Grittleton Parish Council Responses to Relevant Representations. (RR1742)

Title:
Figure 8-4: Agricultural Land Classification

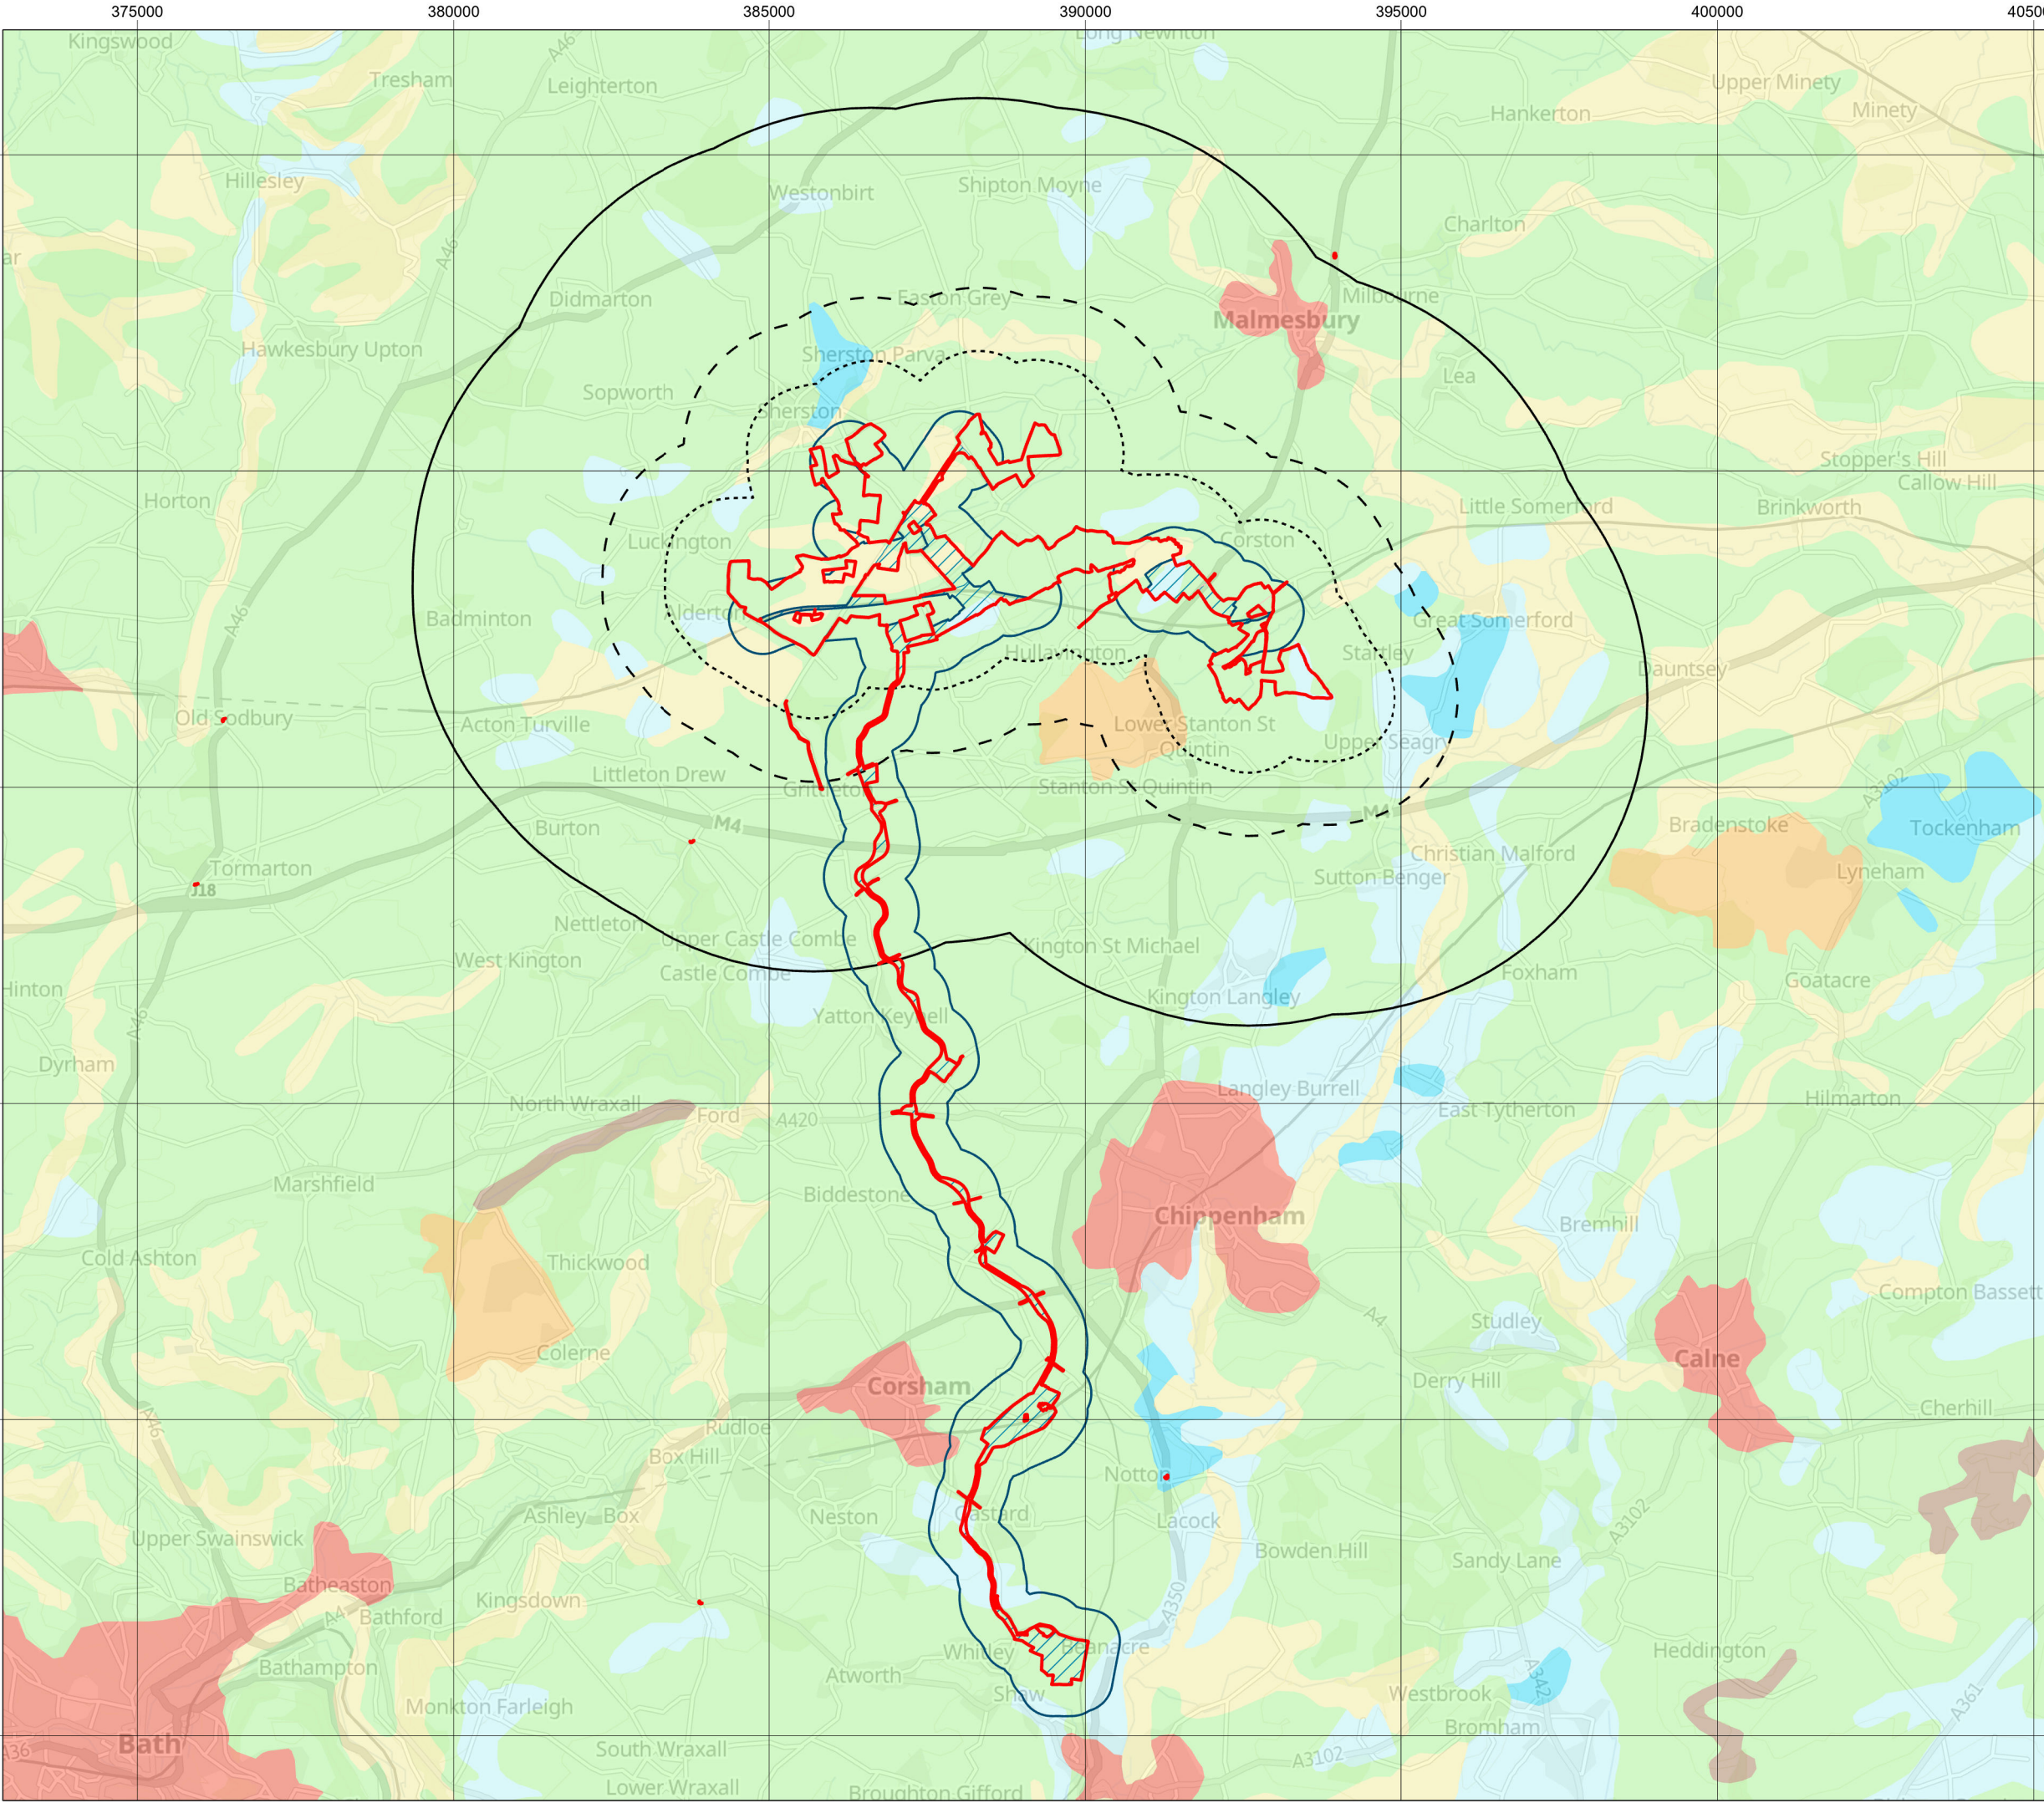
The Agricultural Land Classification (ALC) should be based on historic data from recent arable rotation not a desk top exercise based on historic maps. The impact of sourcing arable crops lost from elsewhere should be taken into account assessing the projects impact.

Title:
Figure 21-2: Location of Cumulative Solar Infrastructure in Proximity to Lime Down Index

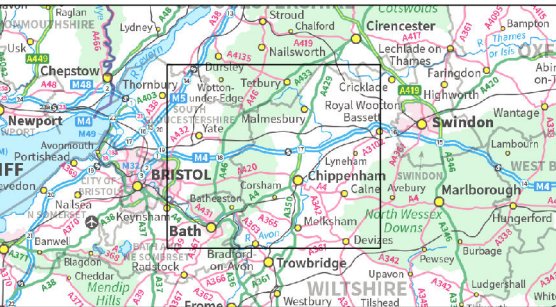
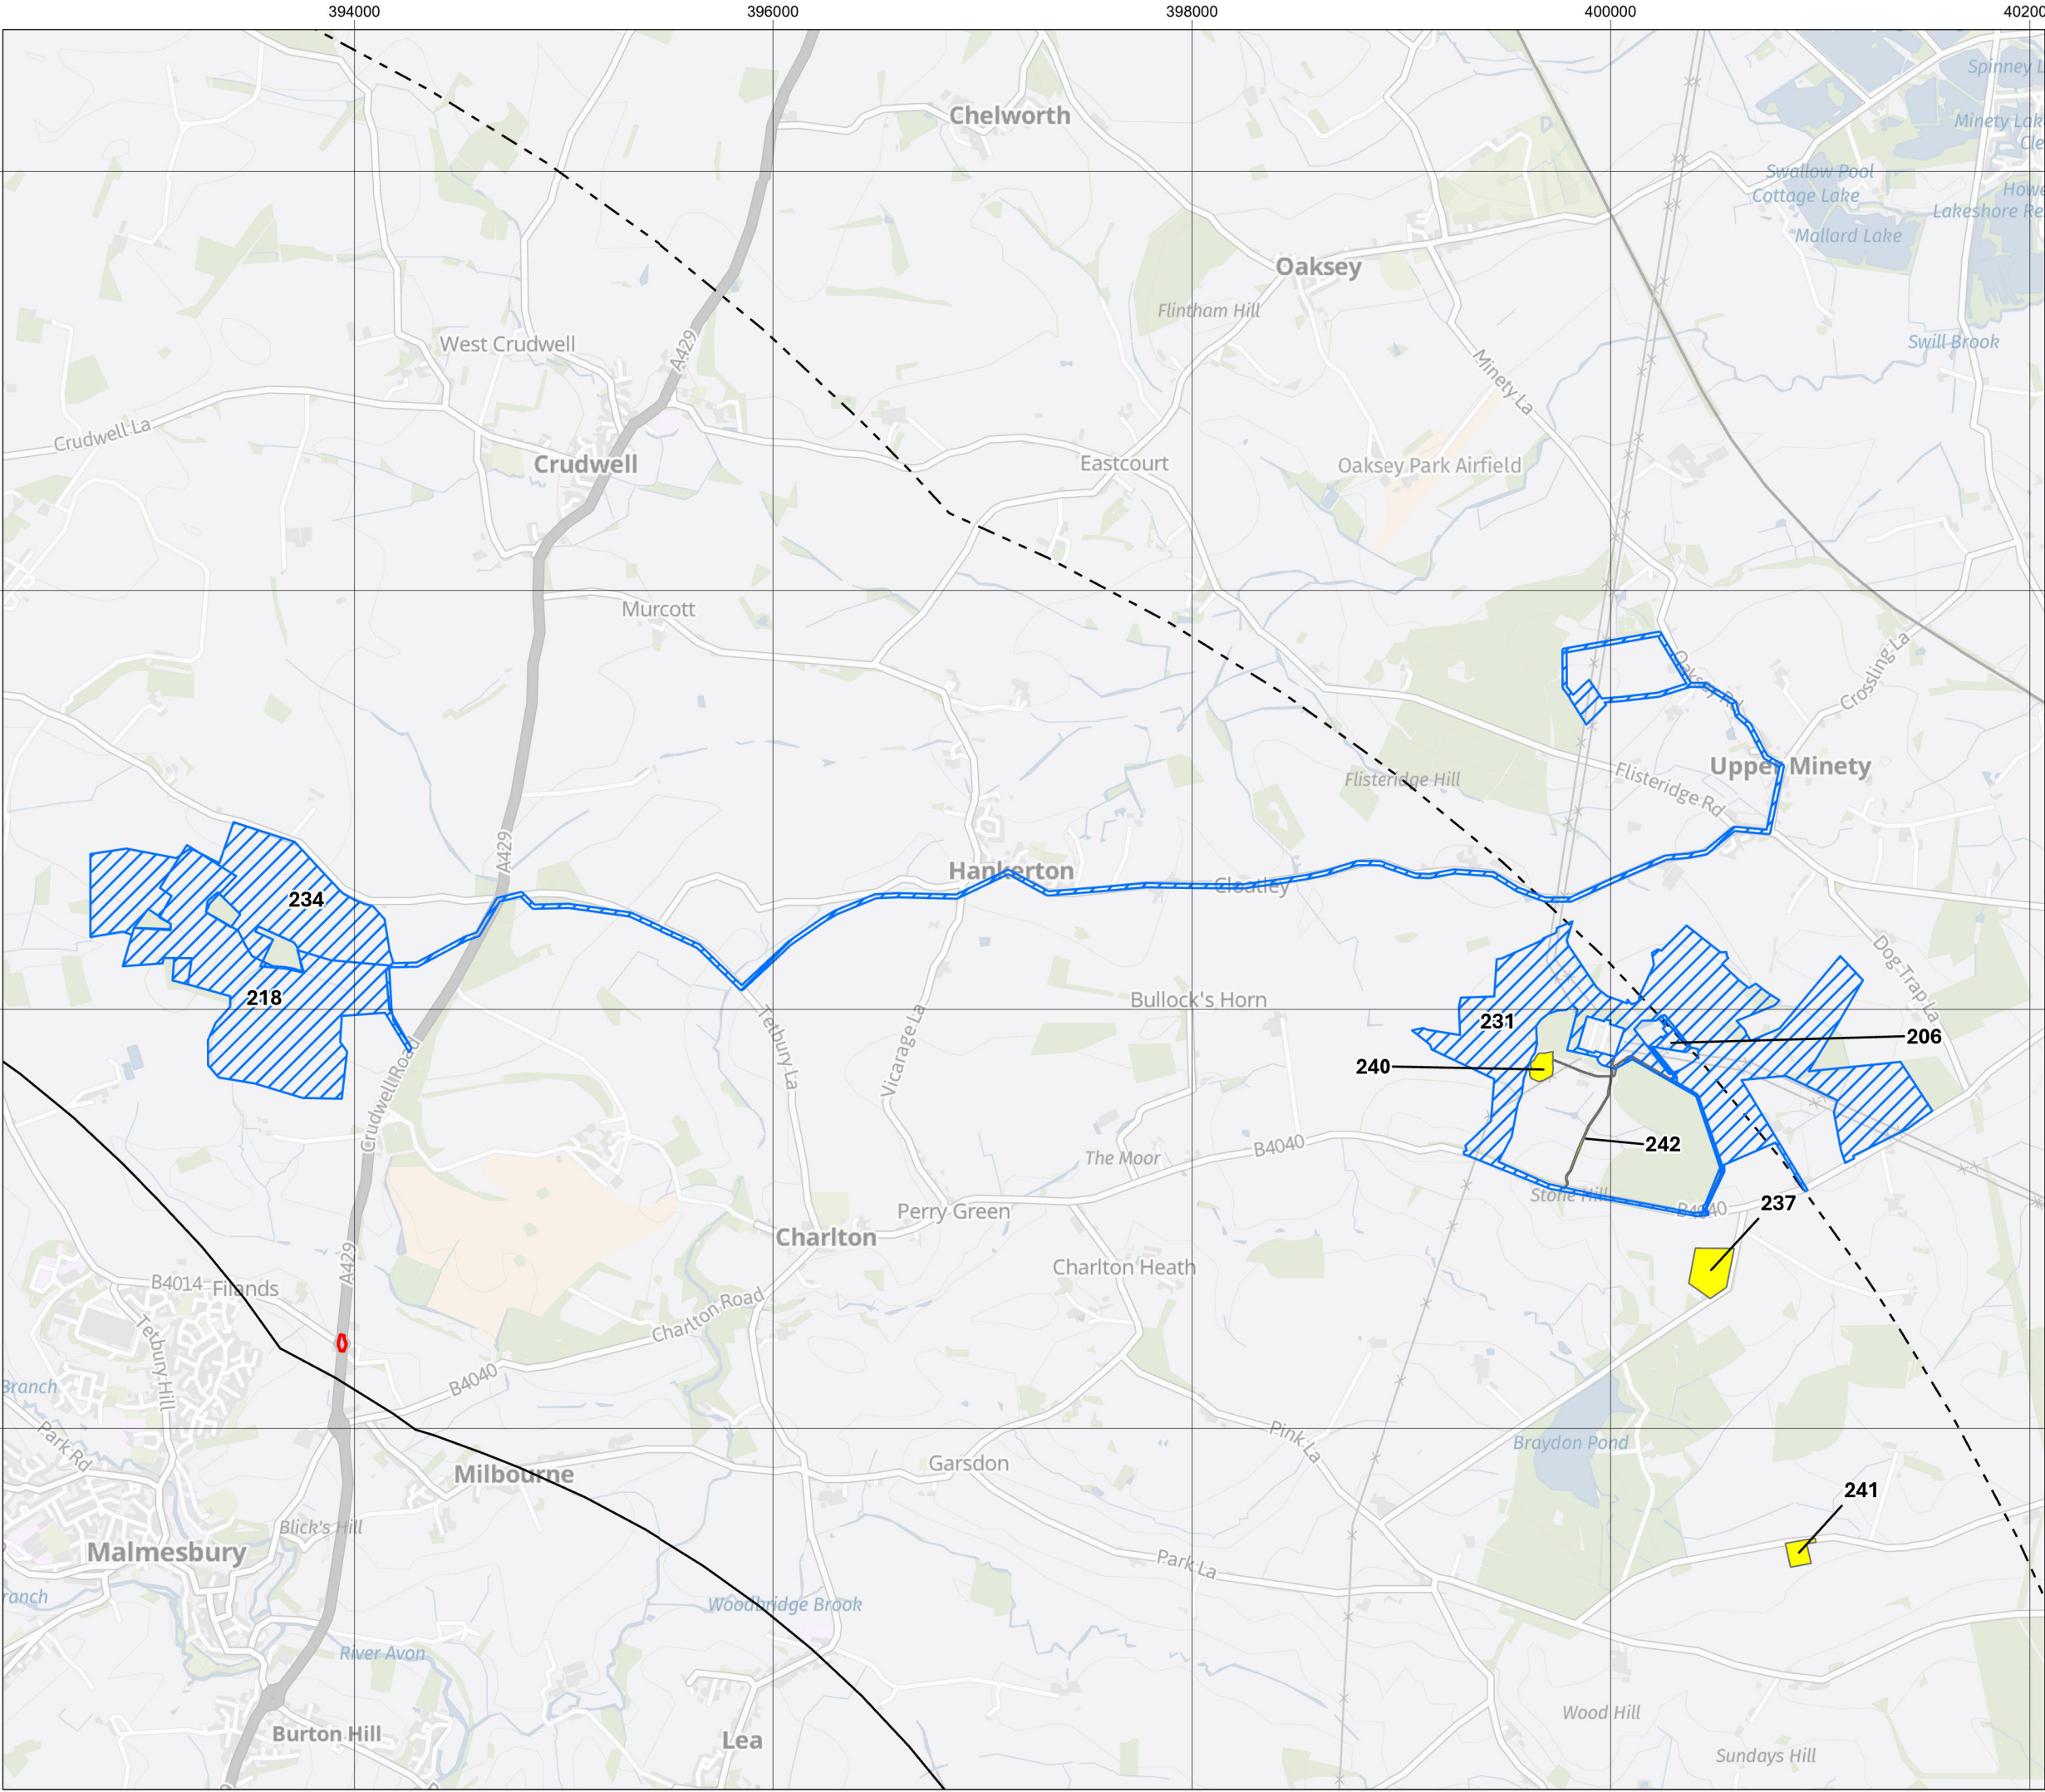
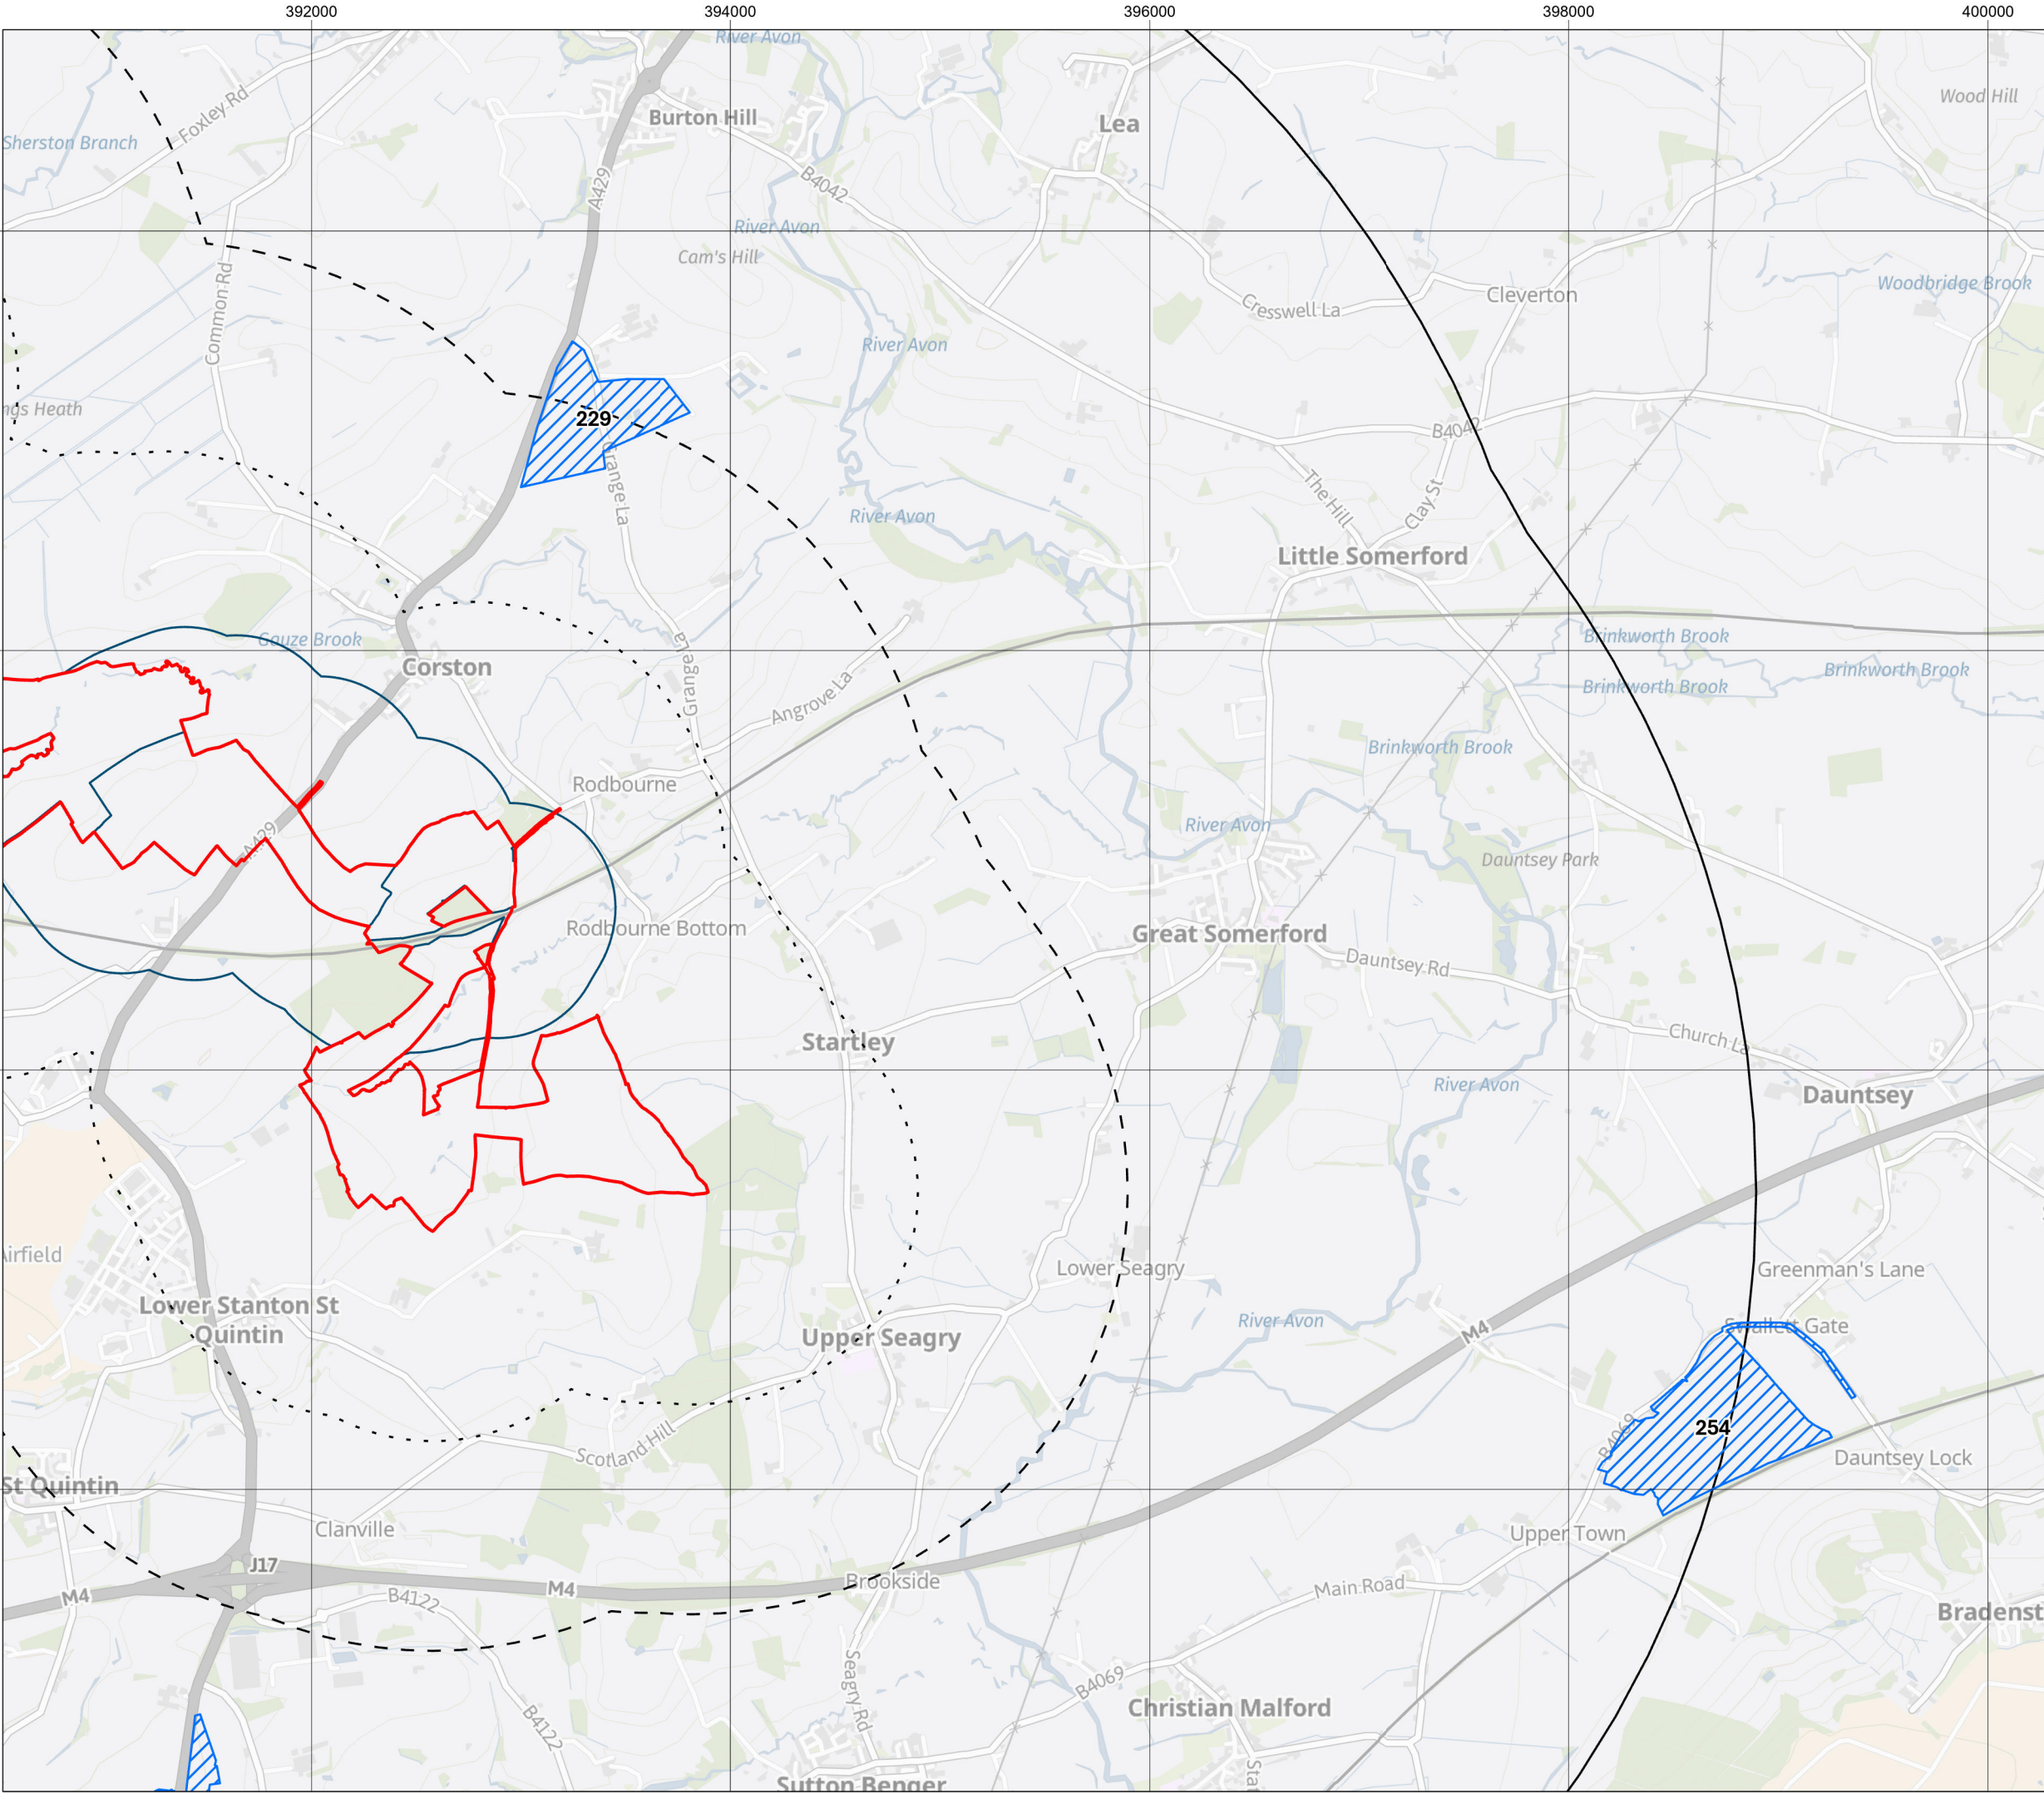
GPC – 004 – Cumulative impact, the 10km study area is too restrictive and should be extended to 20km.
